Office of  
Environment  
& Heritage

DOC18/692798  
SSD 8790

**Exhibition of Alterations and Additions to Parramatta West Public School - Auburn and Young Street, Parramatta (SSD 8790)**

## **Attachment 1 – OEH comments on Exhibition of Alterations and Additions to Parramatta West Public School at Auburn and Young Street, Parramatta (SSD 8790)**

Appendix 1C: Tree Protection Plan - Parramatta West Public School

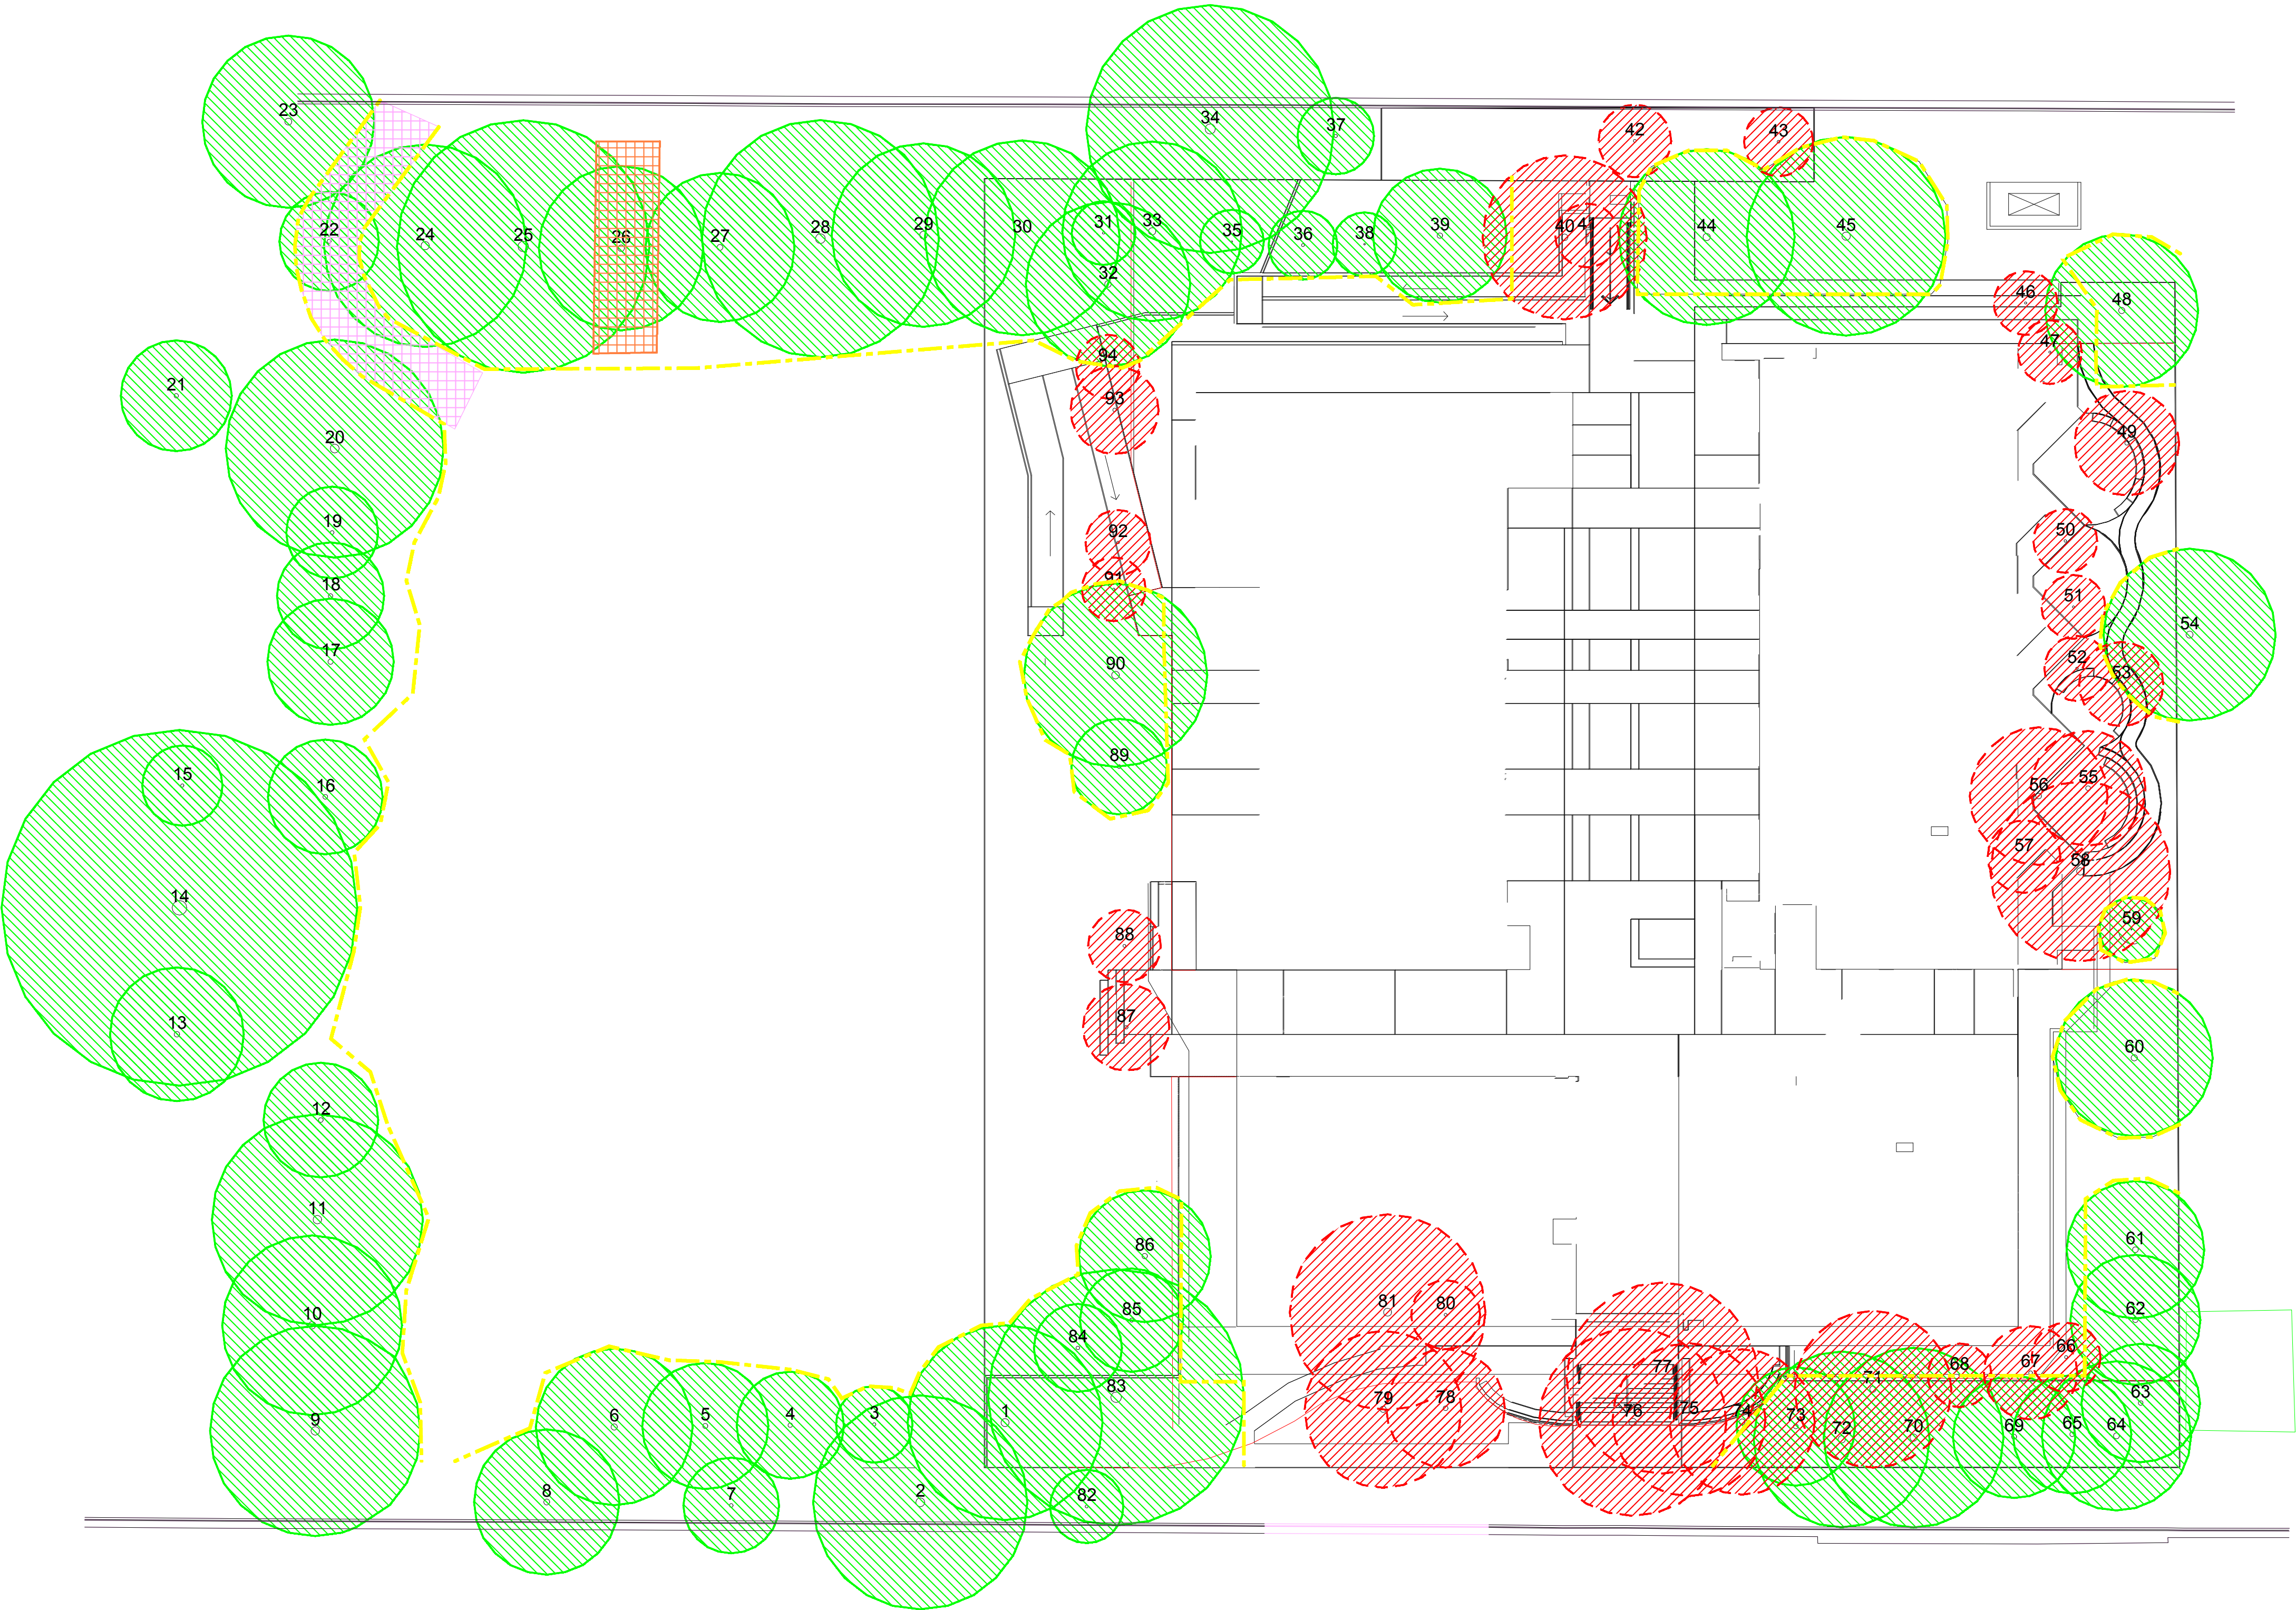
The Arborist reports recommends the *Eucalyptus nicholii* trees No 2, 10, 20 and 23 (street tree) to be retained and protected. However, the Tree Protection zone of Tree 23 may be impacted by the proposal given the preferred vehicular access road encroaches into the TPZ as shown on the Tree Protection Plan by Urban Arbor P/L. A comparison of the landscape and architectural plans with the Arborist report reveals that the proposed building works are unlikely to impact on the (Tree Nos 2, 10, 20). These trees have been identified as threatened species and OEH previously advised in its letter dated 4 September 2018 in agreeing to a Biodiversity Development Assessment Report waiver (BDAR) that "if the footprint of this project changes such that the three trees of the threatened species, Narrow-leaved Black Peppermint (*Eucalyptus nicholii*) which occur on the northern and western boundaries of the site are impacted, an assessment of significance in accordance with section 7.3 of the *Biodiversity Conservation Act 2016* should be undertaken prior to approval. The outcome of this assessment may affect this decision to waive the requirement for a BDAR."

- In accordance with the recommendations of the Arborist report, the *Eucalyptus nicholii* Trees No 2, 10, 20 and 23 that are threatened species are to be retained and protected.
